Application Comment Report

Application No. LUPL-25-0008

Record Type : Land Use Plan

Document: 241010_BLR Village C Land Use Plan.pdf

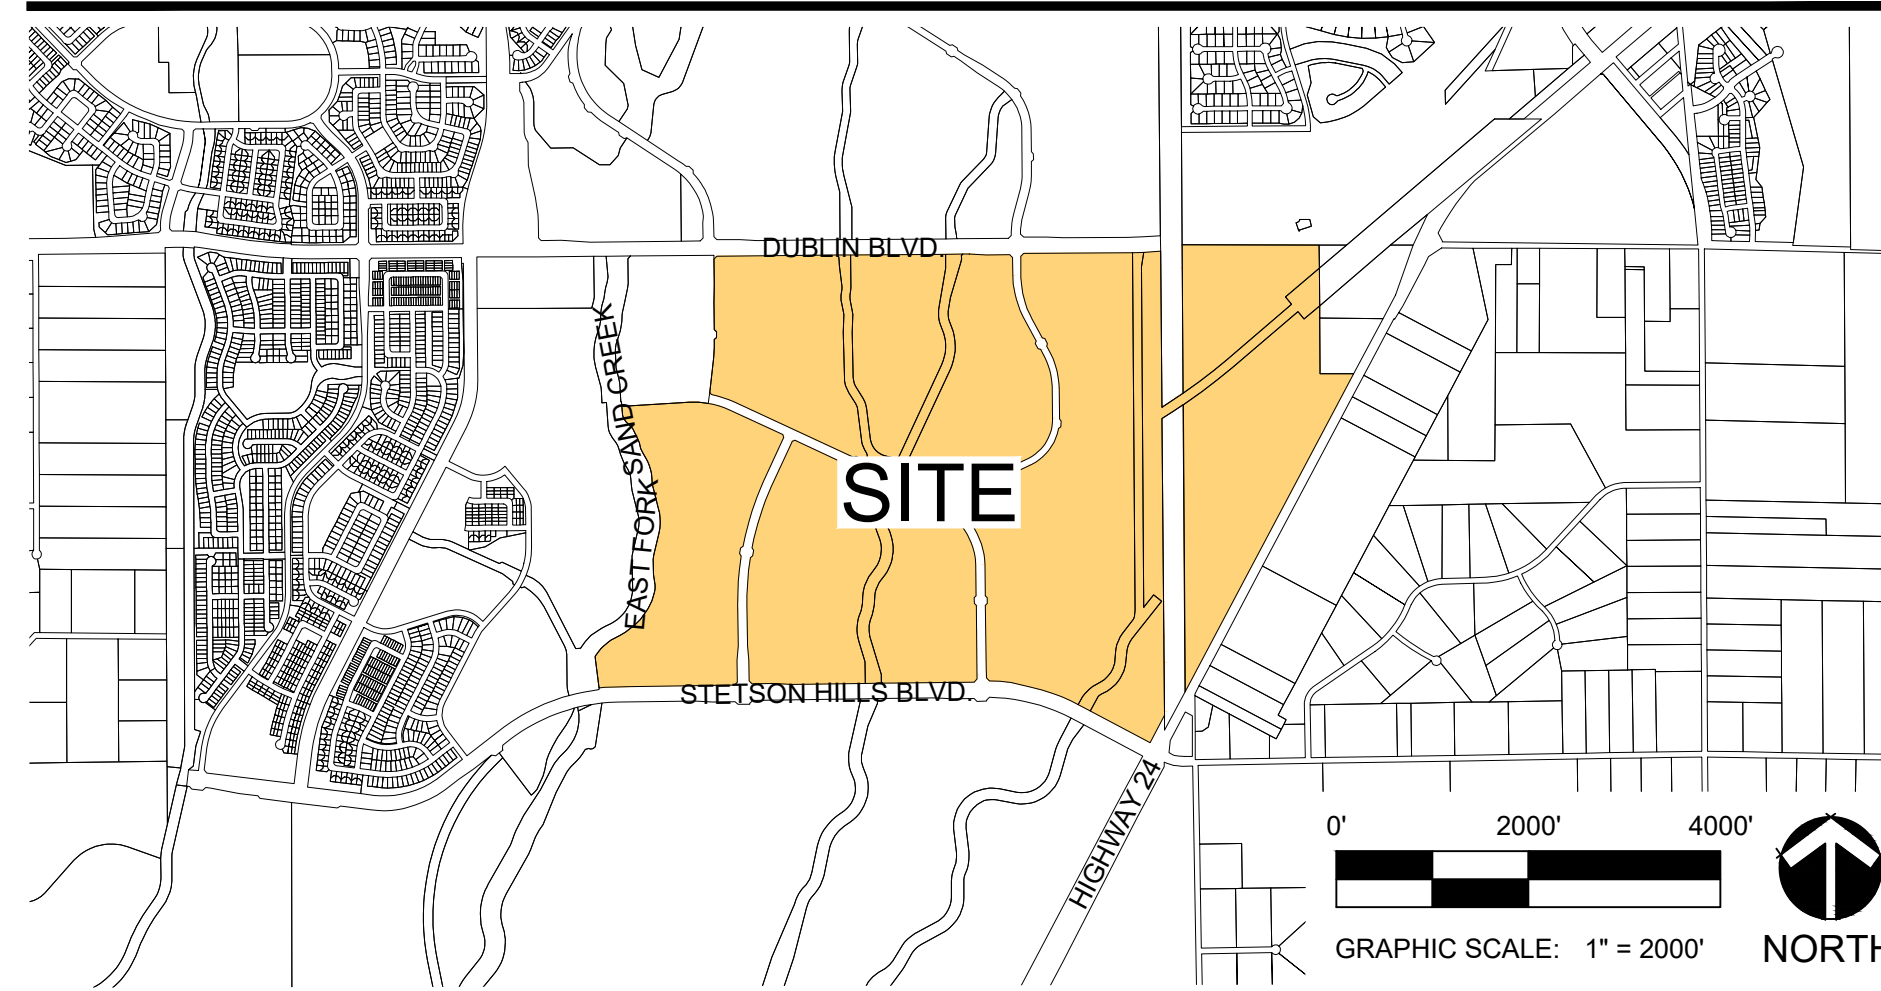
| Comment ID | Page Reference | Annotation Type | Reviewer : Department | Status | Review Comments | Applicant Response Comments |
|------------|----------------|-----------------|----------------------------|--------|---|---|
| 74 | 1 | Note | Tamara Baxter : Planning | Open | Expand GN # 26. All of the Development Standards Adjustment city files shall be identified and description of the DSA. A table format may be the best. | Guest - 10-28-2025 15:19:36 A table has been added identifying the city filing numbers and the associated adjustment. |
| 79 | 1 | Callout | Tamara Baxter : Planning | Open | Per UDC Section 7.3.201, SF detach is a conditional use in the MX-M zone district. Please note as such. Also Manufacture homes is not permitted. | Guest - 10-28-2025 15:22:12 SF detached is now identified as a conditional use in the table. |
| 80 | 1 | Callout | Tamara Baxter : Planning | Open | Verify these parcels. Lot 6 is proposed to be R-Flex Med. | |
| 82 | 1 | Callout | Tamara Baxter : Planning | Open | verify that all the acreage match those on sheet 2 | |

LAND USE PLAN

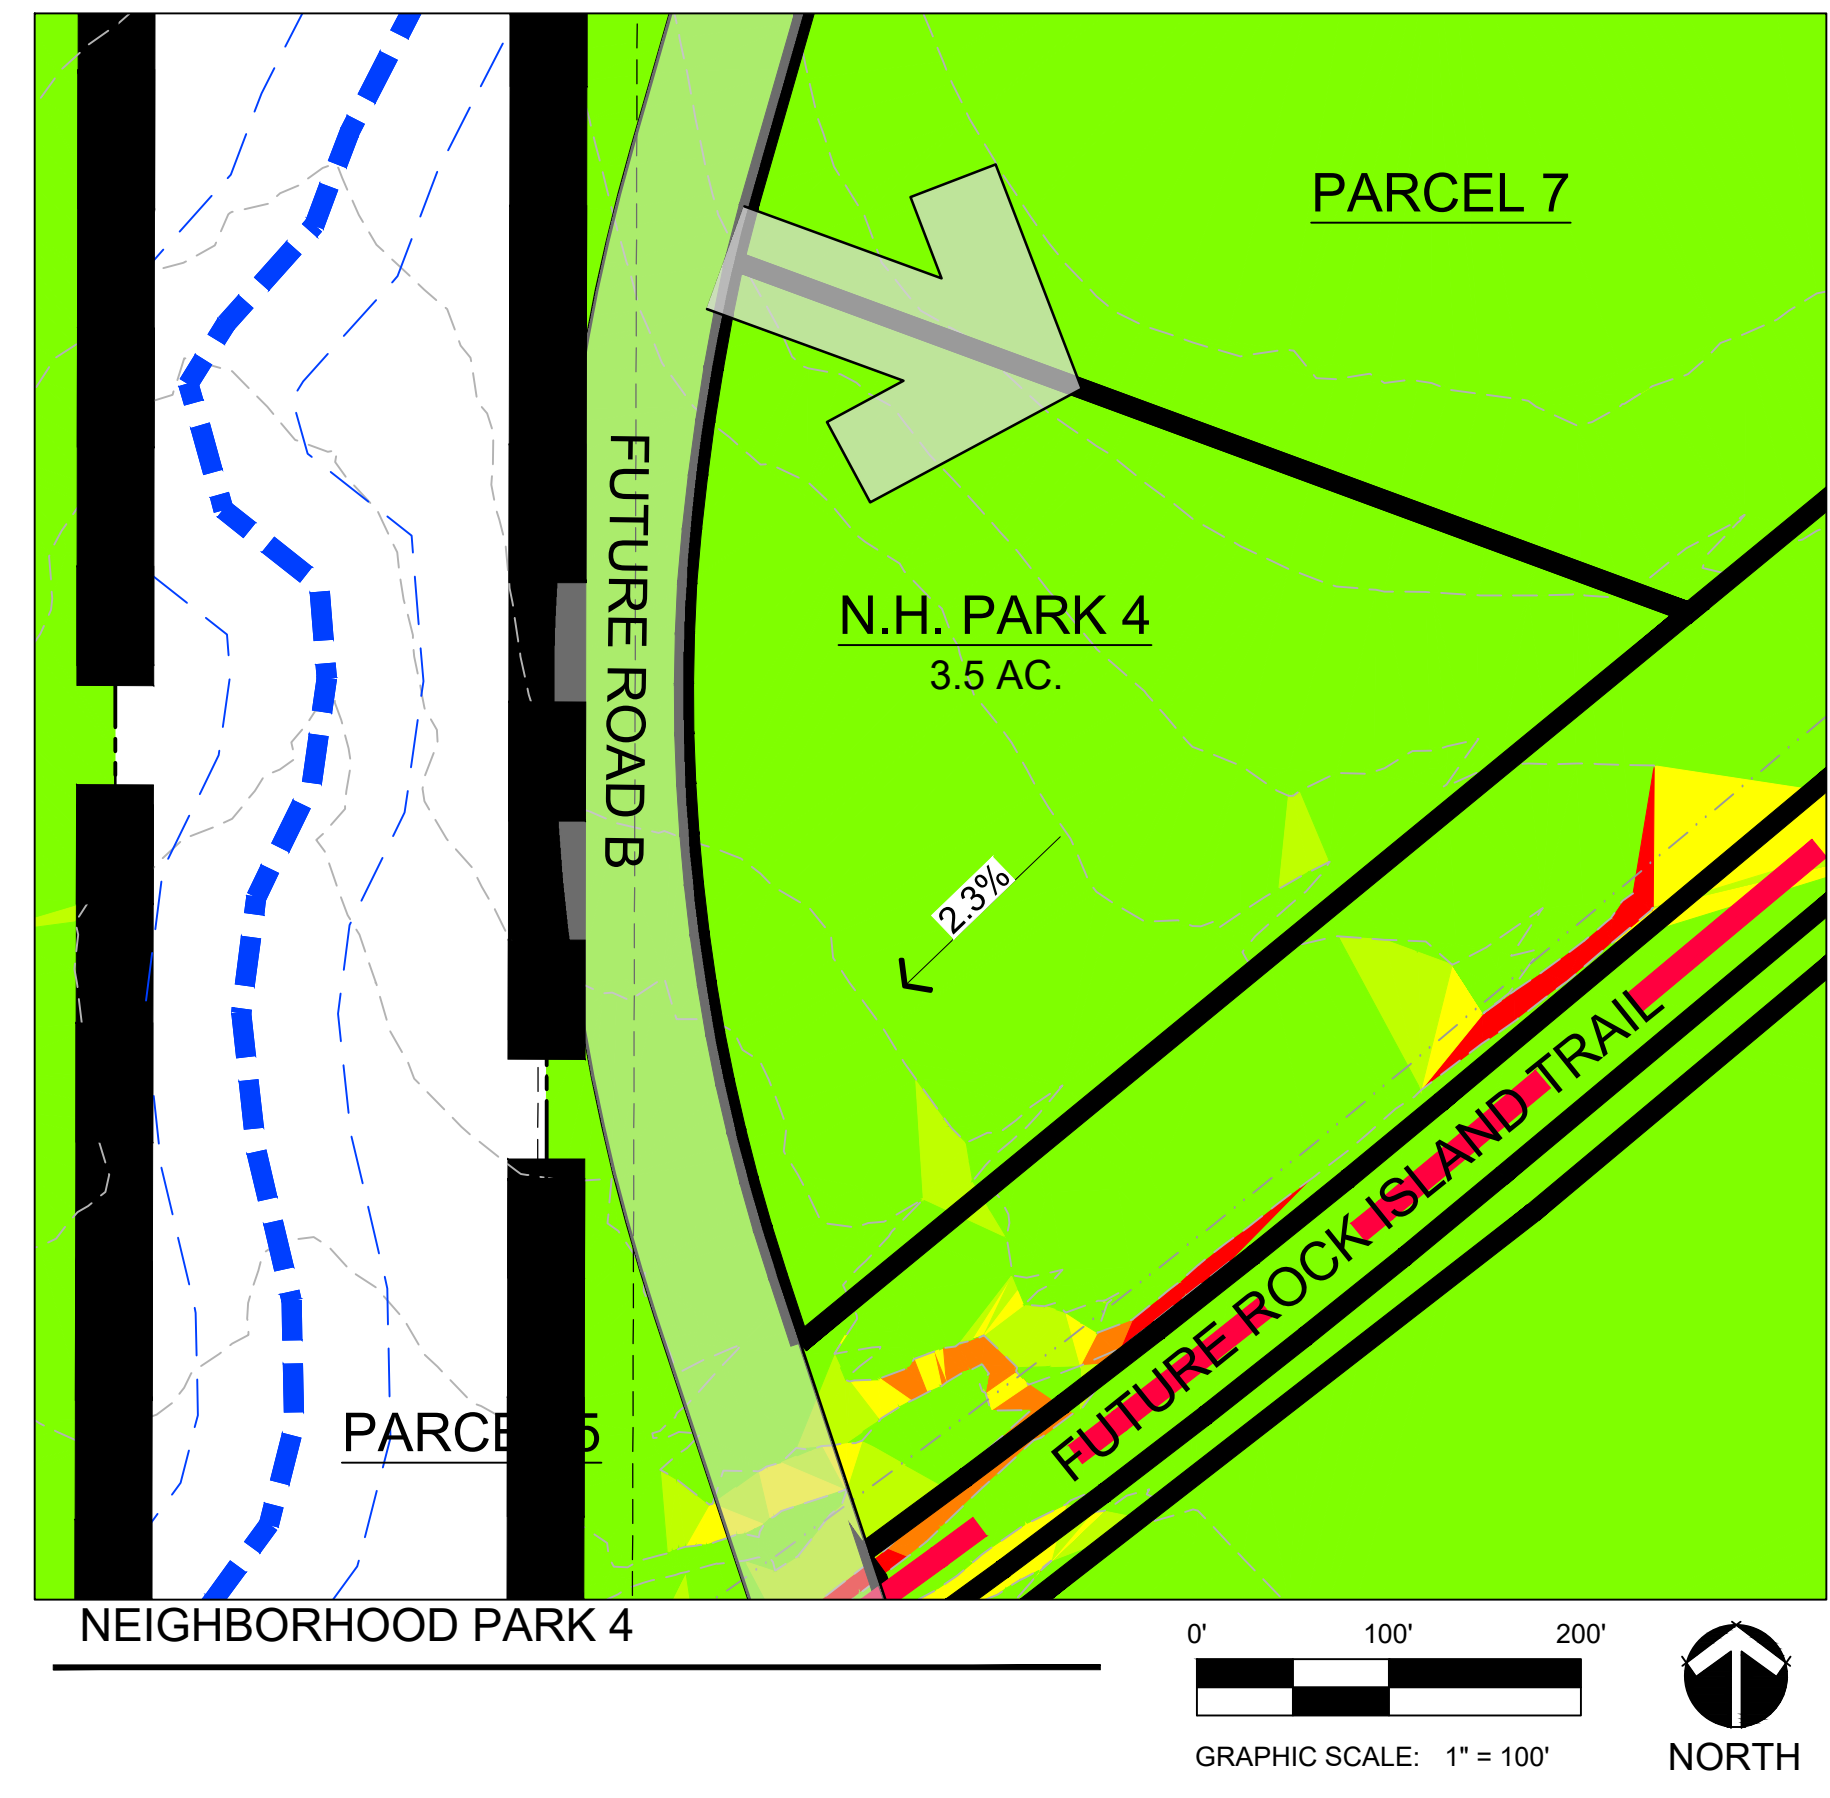
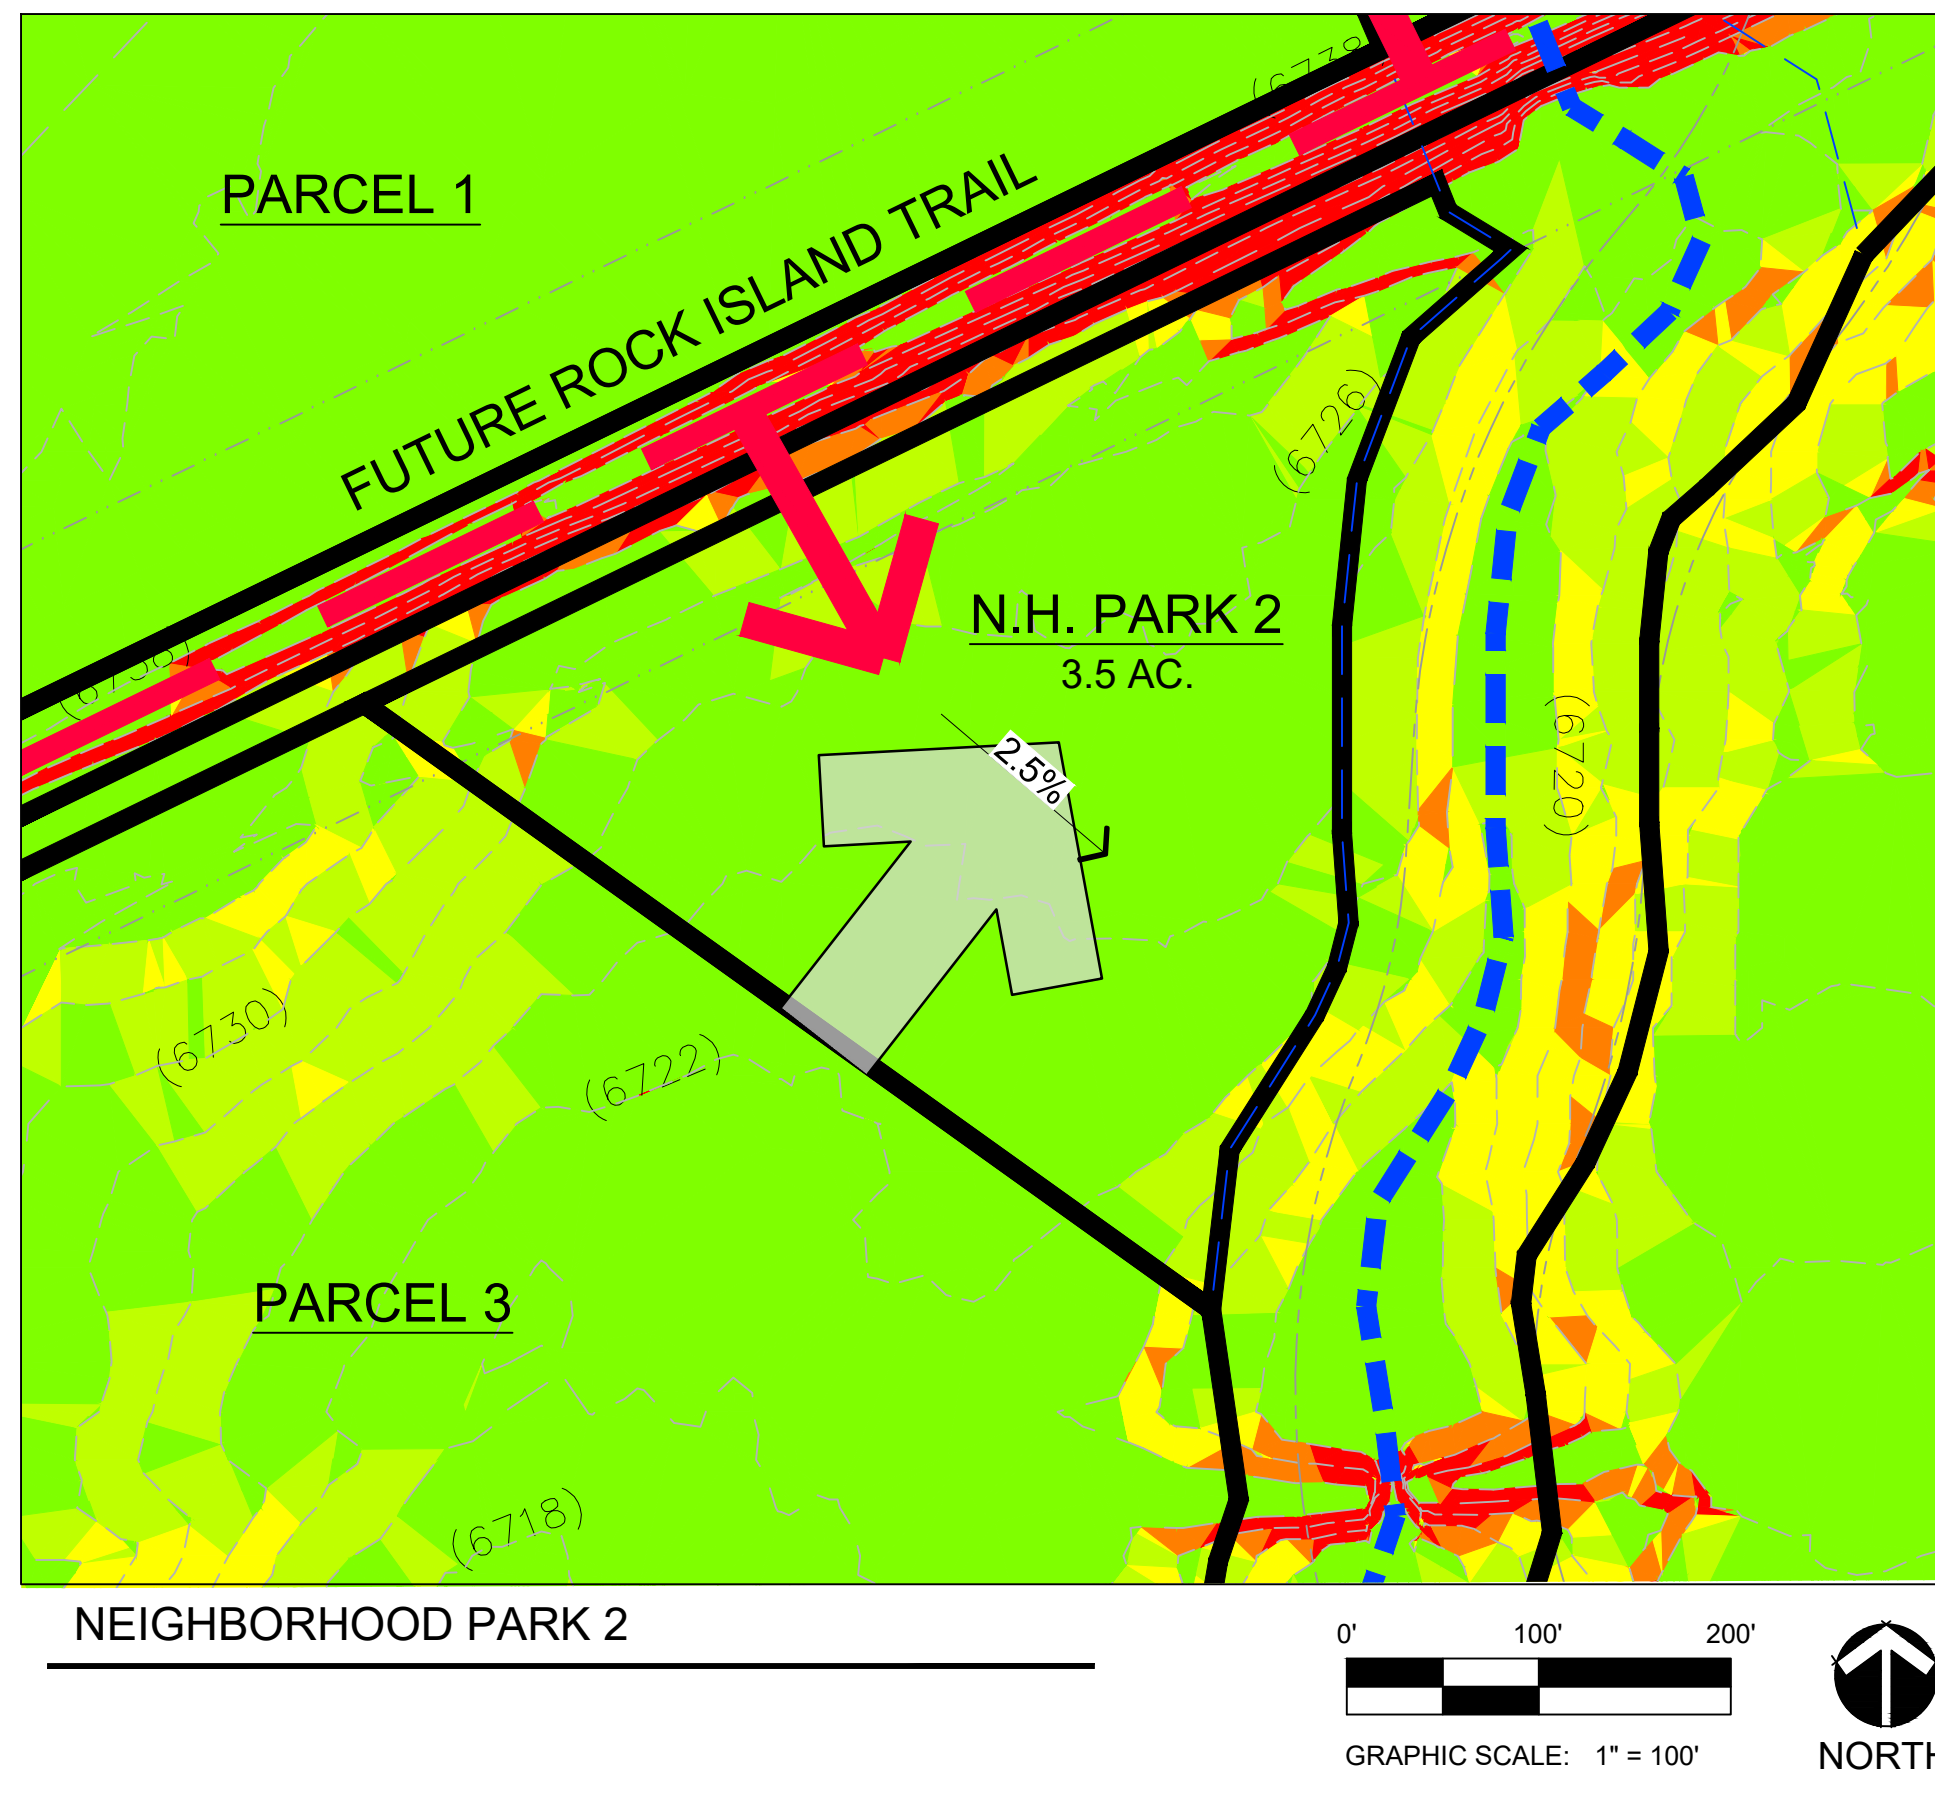
| Comment ID | Page Reference | Annotation Type | Reviewer : Department | Status | Review Comments | Applicant Response Comments |
|------------|----------------|-----------------|--|--------|---|--|
| 2 | 2 | Note | Zaker Alazzeh : City Eng - Traffic Engineering | Open | The developer shall dedicate the appropriate right-of-way along the northern property line of Parcel 6, located on Dublin Boulevard. This dedication must align with the western property line right-of-way existing roadway and meet the city's standards. Please coordinate with city traffic engineering on the ROW dedication. | <p>Guest - 10-28-2025 15:04:11</p> <p>Dublin Blvd north of Parcel 7 now has a 70' ROW per the 9/8/2025 meeting with Oakwood, LAI, Classic Consulting, City Traffic, and El Paso County Engineer.</p> |

| Comment ID | Page Reference | Annotation Type | Reviewer : Department | Status | Review Comments | Applicant Response Comments |
|------------|----------------|-----------------|----------------------------|--------|---|---|
| 70 | 2 | Note | Caroline Miller : Planning | Open | Please revise cells to match above unit counts. | |

| Comment ID | Page Reference | Annotation Type | Reviewer : Department | Status | Review Comments | Applicant Response Comments |
|------------|----------------|-----------------|----------------------------|--------|---|--|
| 71 | 2 | Note | Caroline Miller : Planning | Open | <p>With the change to Community Park acreage, staff would like to understand the road connections for the Community Park site and the residential area to the south. What is the thought for the road design? Will a connector road be built through the Community Park site, connecting to the residential area, thereby limiting the Community Park acreage to a full-access public road?</p> <p>In addition, will there be any other road access points off of Dublin, or just the Community Park area? Feel free to reach out to the reviewer to discuss in a meeting if preferred.</p> | <p>Guest - 10-28-2025 15:17:40</p> <p>Noted and a meeting with parks will be scheduled at the appropriate time.</p> |
| 75 | 2 | Callout | Tamara Baxter : Planning | Open | <p>What is the zoning for this area? Please call out.</p> | <p>Guest - 10-28-2025 15:22:33</p> <p>Zoning label added.</p> |
| 76 | 2 | Callout | Tamara Baxter : Planning | Open | <p>Please call out zoning for this area.</p> | <p>Guest - 10-28-2025 15:17:59</p> <p>Zoning label added.</p> |
| 77 | 2 | Callout | Tamara Baxter : Planning | Open | <p>Please call out zoning for this area. Should be reflective of the area shown in ZONE-25-0020</p> | <p>Guest - 10-28-2025 15:22:44</p> <p>Zoning label added.</p> |
| 78 | 2 | Callout | Tamara Baxter : Planning | Open | <p>Please call out zoning for this area. Should be reflective of ZONE-25-0021</p> | <p>Guest - 10-28-2025 15:21:01</p> <p>Zoning label added.</p> |

| Comment ID | Page Reference | Annotation Type | Reviewer : Department | Status | Review Comments | Applicant Response Comments |
|------------|----------------|-----------------|----------------------------|--------|---|---|
| 81 | 2 | Callout | Tamara Baxter : Planning | Open | As noted on the cover sheet, SF detached are conditional use in the MX-M zone district | Guest - 10-28-2025 15:23:14 SF detached is now identified as a conditional use in the table. |
| 83 | 2 | Note | Tamara Baxter : Planning | Open | Please clean up overlap so text is legible. | |
| 88 | 2 | Callout | Tamara Baxter : Planning | Open | Will future residential in this area be limited to the 3-156 du/ac, similar to R-Flex Med? | |
